RE: **Lot 12 Block 4 Volcano Cliffs Unit 19**  
**6511 Vista Del Prado NW**  
**Grading and Drainage Plan**  
**Engineers Stamp Date: 11/6/2023 (D10D003T12)**  
**Pad Certification Date: No Date**

Based upon the information provided in your submittal received 12/18/2023, this plan cannot be approved for building permit until the following comment is addressed.

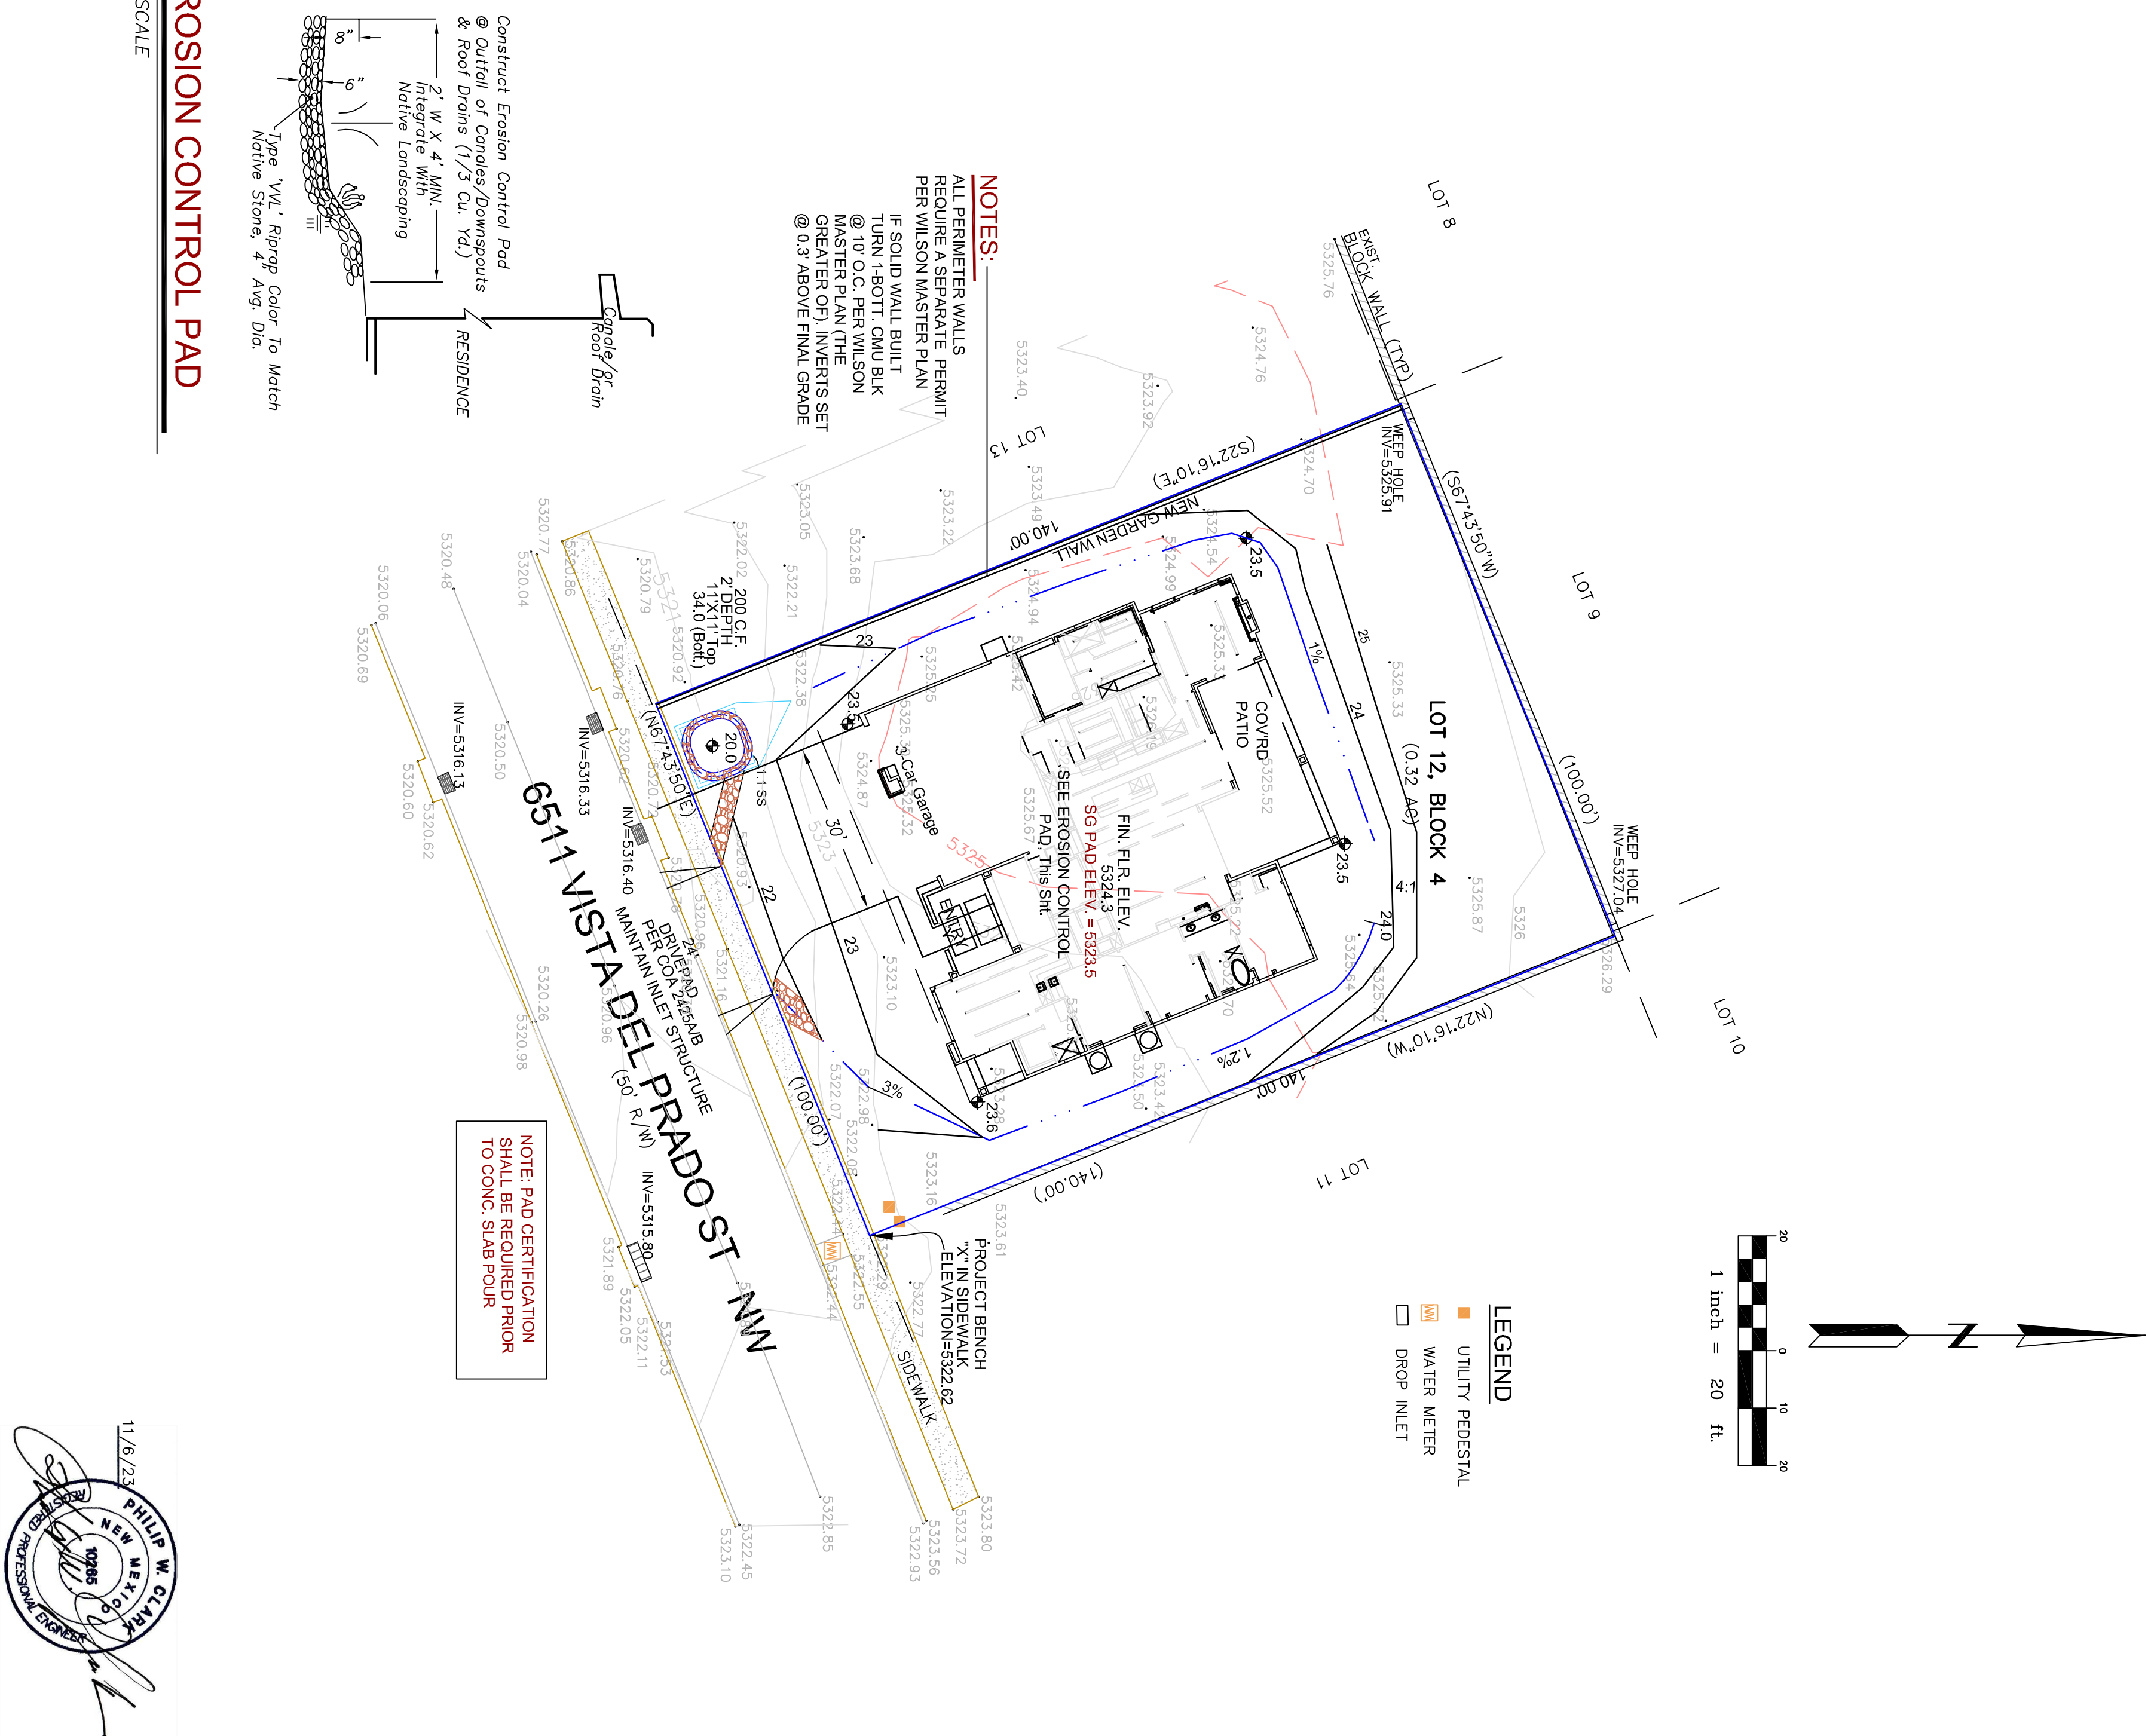
- **Provide the pad certification language on the grading plan with your signature and date you approved the site for building permit. After receiving this plan a site visit will be conducted.**

**Advise the owner contractor not to use dirt as a ramp to climb the curb, use lumber or crusher fines for this purpose. Place this note on the plan.**
